Please upload the below to the above applications. Conservation Officer comments.

## Y/105/19/PL & Y/106/19/L

The proposal is for the conversion of, and alterations to, existing barns to create 3 dwellings, along with the erection of car barns, a store, a replacement pump house, demolition of a C20 barn and associated landscaping and parking.

Drawing Title	Proposed Plans - Barn 3
Scale	1:100 @ A3

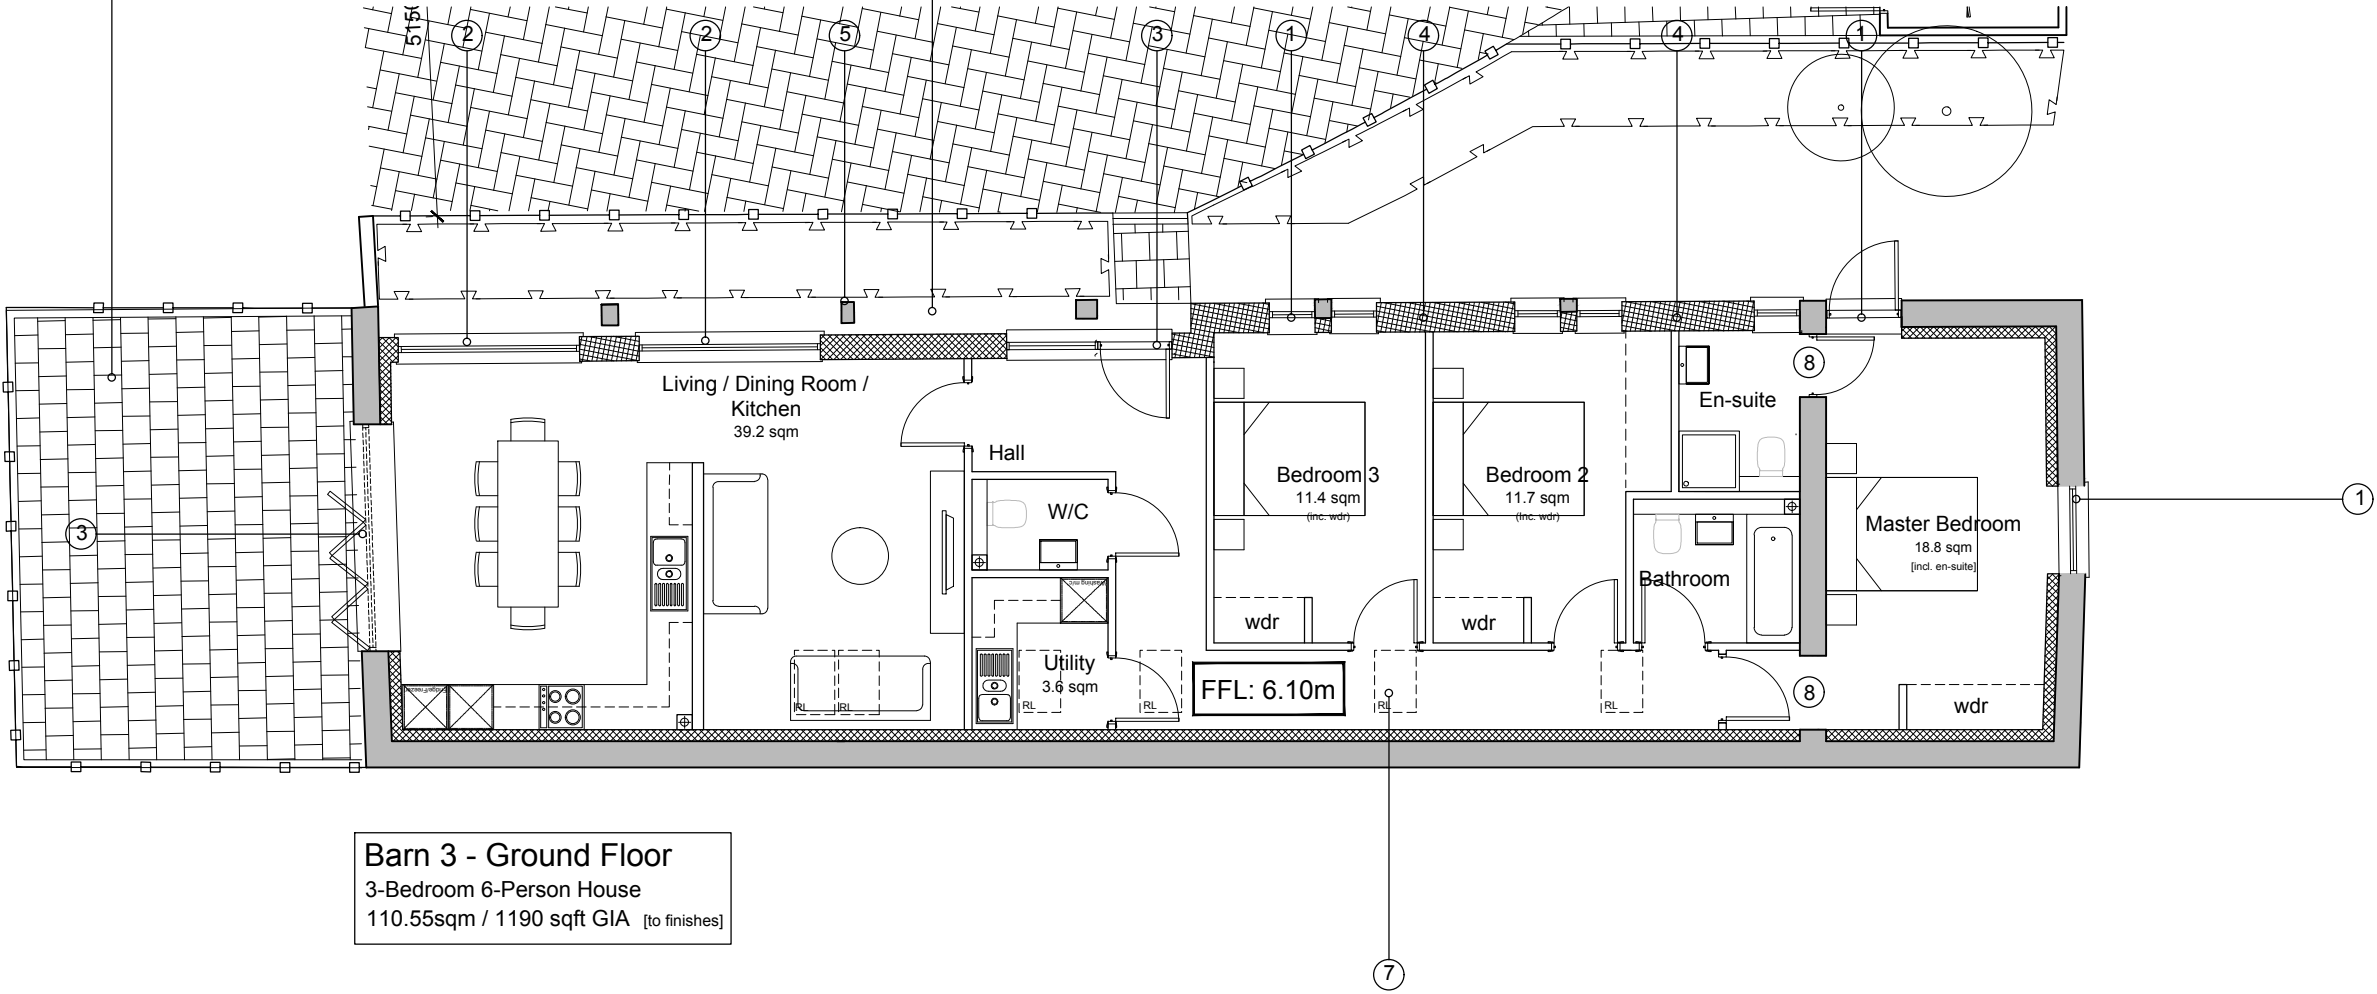
Likewise, it is noted that the building referred to as 'barn 3' is to include bi-folding doors. Such a feature is not normally associated with a barn and cannot be supported here. It is suggested that an alternative approach be considered which would result in the loss of less historic fabric, and a more appropriate design.
